Subject: Planning Application Comments - 3/2025/0588 FS-Case-742091111

Planning Application Reference No.: 3/2025/0588

Address of Development: Land East of Clitheroe Road Whalley

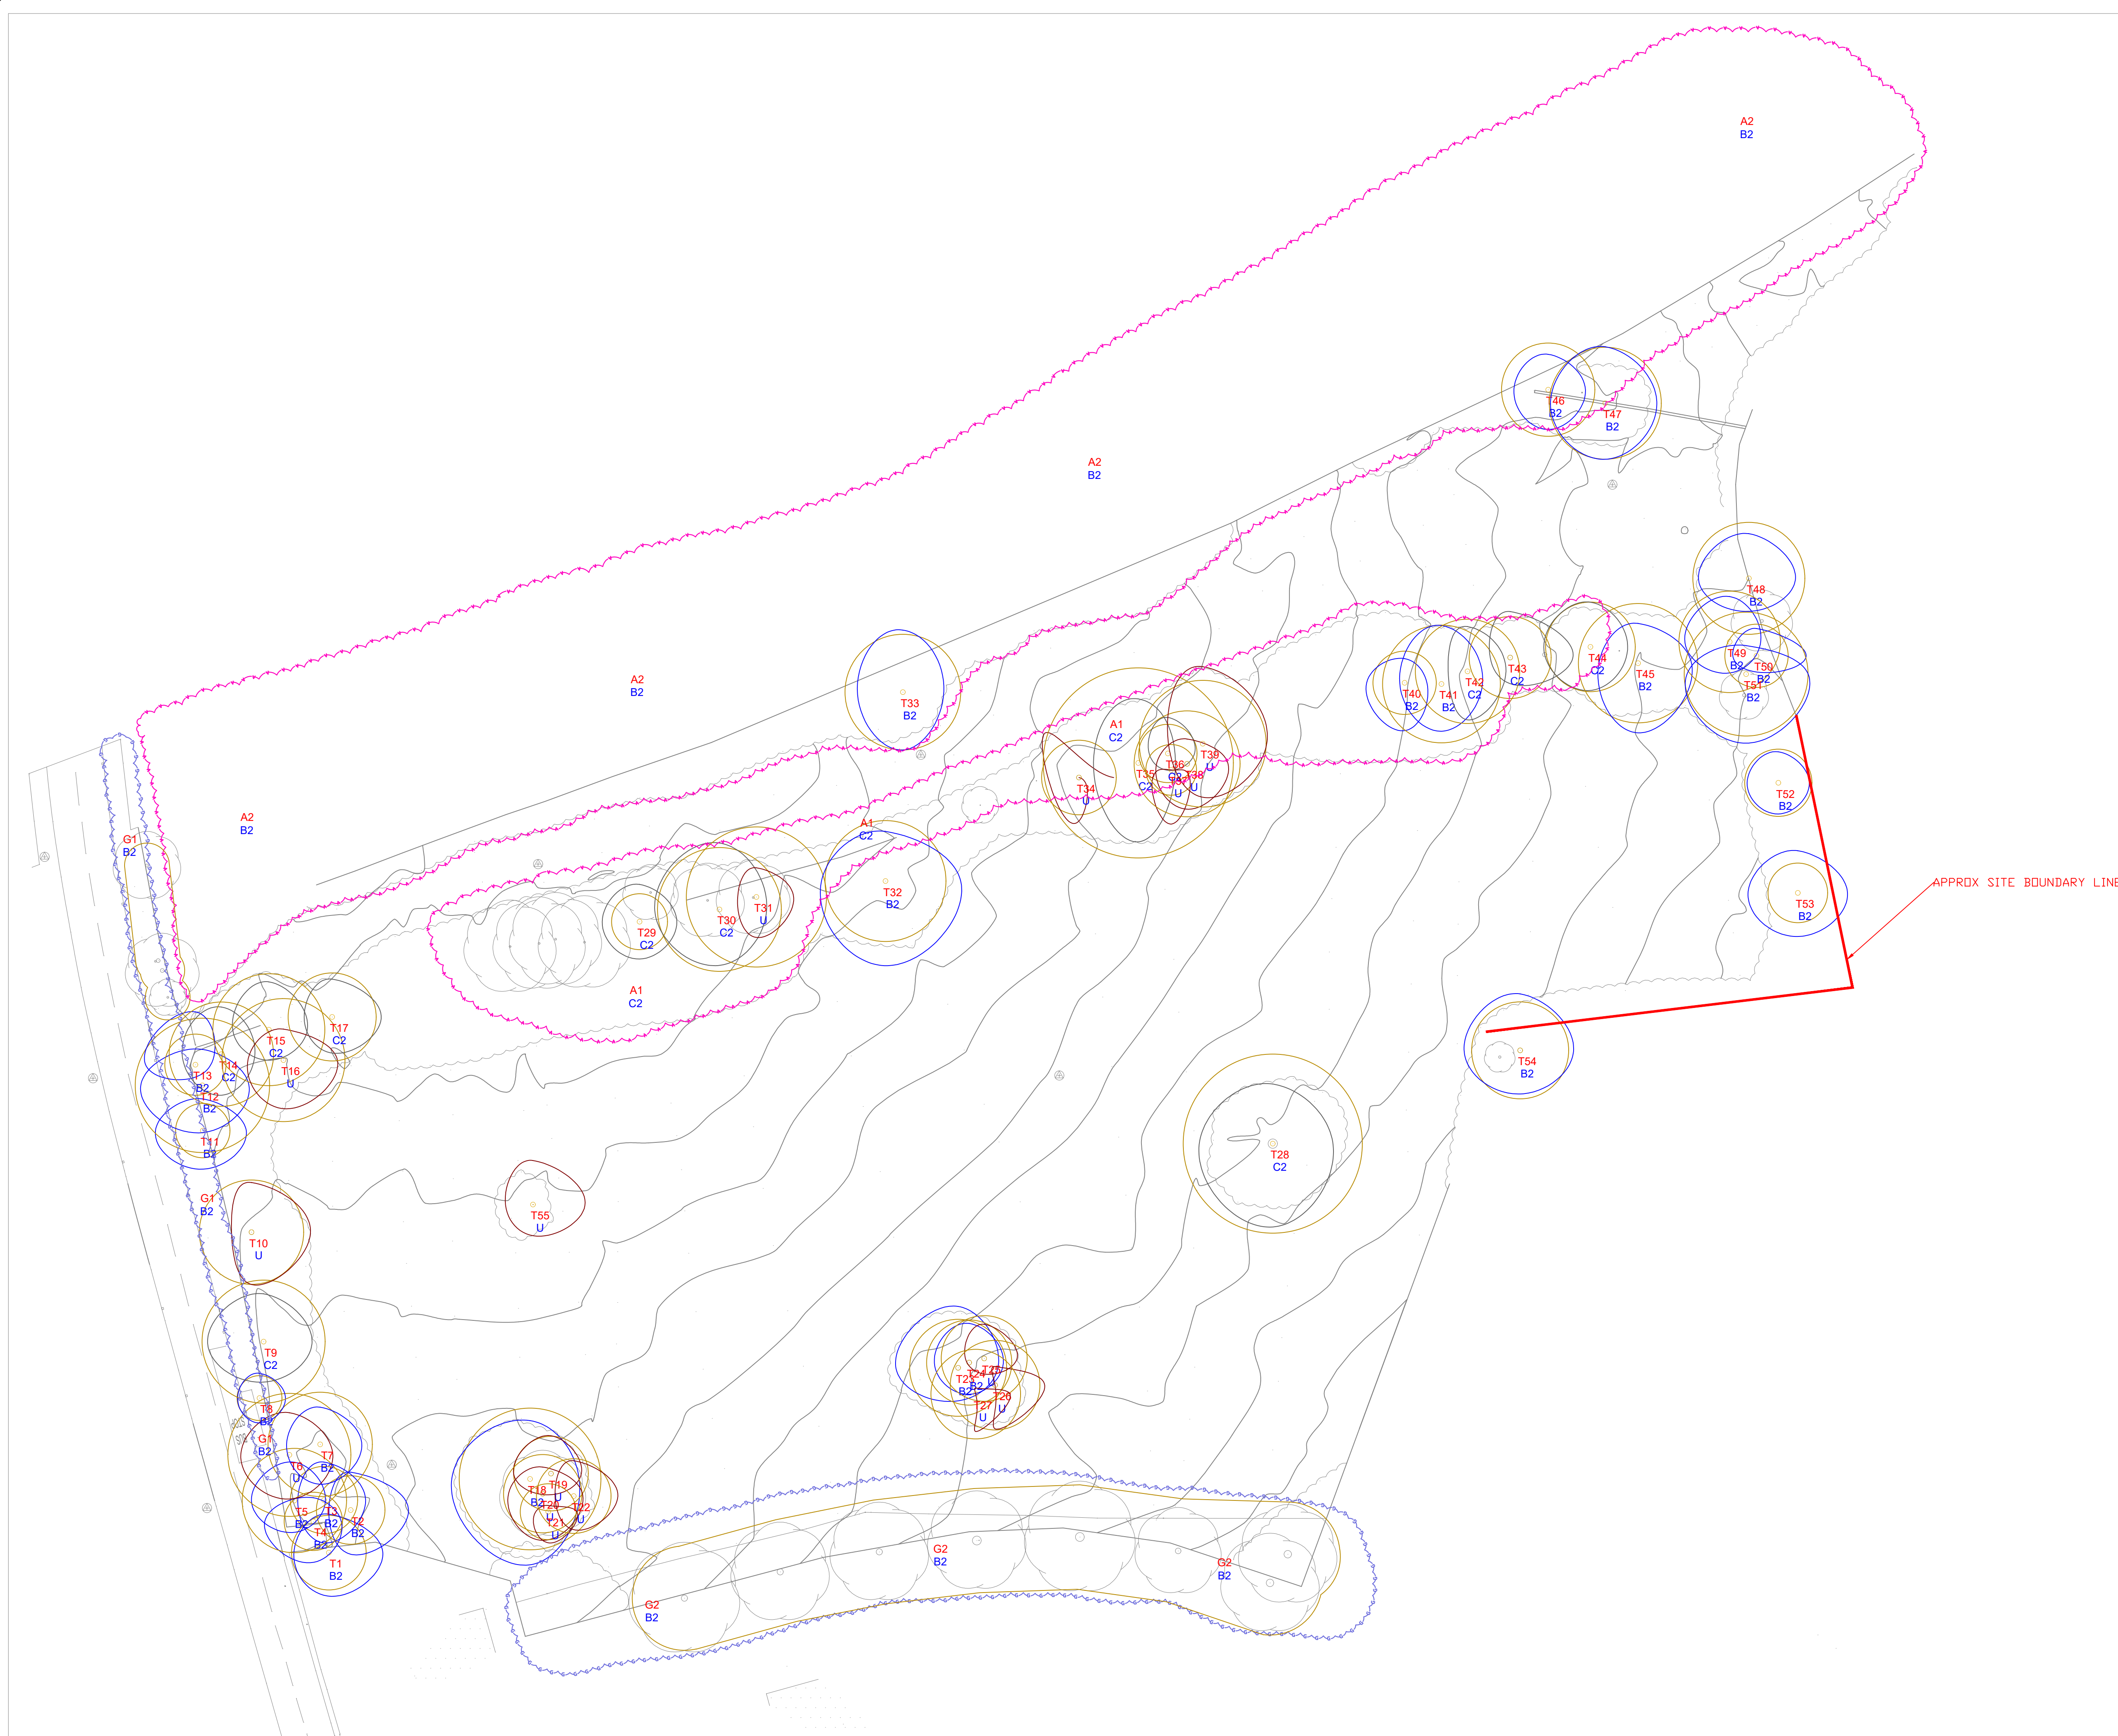
8. As we read it, the application does mention the three mature Lime trees which are on the same side of Bramley Meade Hall's driveway as the proposed development and so are at its boundary, but we submit that the Tree Impact Assessment and Survey refers to these trees inaccurately or misleadingly. The arboricultural consultant says that "no trees along its boundaries" have TPOs. This is wrong. These trees are all marked as G2 on the plan. In the Report they are referred to as being off site by "the highway". But there is no highway.

They are in the verge of the <u>private</u> driveway to Bramley Meade Hall. All have TPOs. Their height is estimated at 25 metres. We note the root protection provision but this is to protect the trees during construction. We are more concerned by safety risks after construction. The report does <u>not</u> however appear to indicate how many metres from those trees the closest of the houses would be, but we would estimate much less than 25 metres. Some of the houses of plots 13-22 and 37-46 would appear to be within a few metres of those very tall trees and well within falling distance. Is there not some restriction on building new houses so close to mature trees? Would it not be good practice only to build at least as far away as their height, in this case 25 metres?

9. Indeed, they would probably be within falling distance of a height and maturity as the G2 trees (and also has a TPO). This tree is <u>not</u> mentioned in the report and is not covered by the root protection proposal although it i
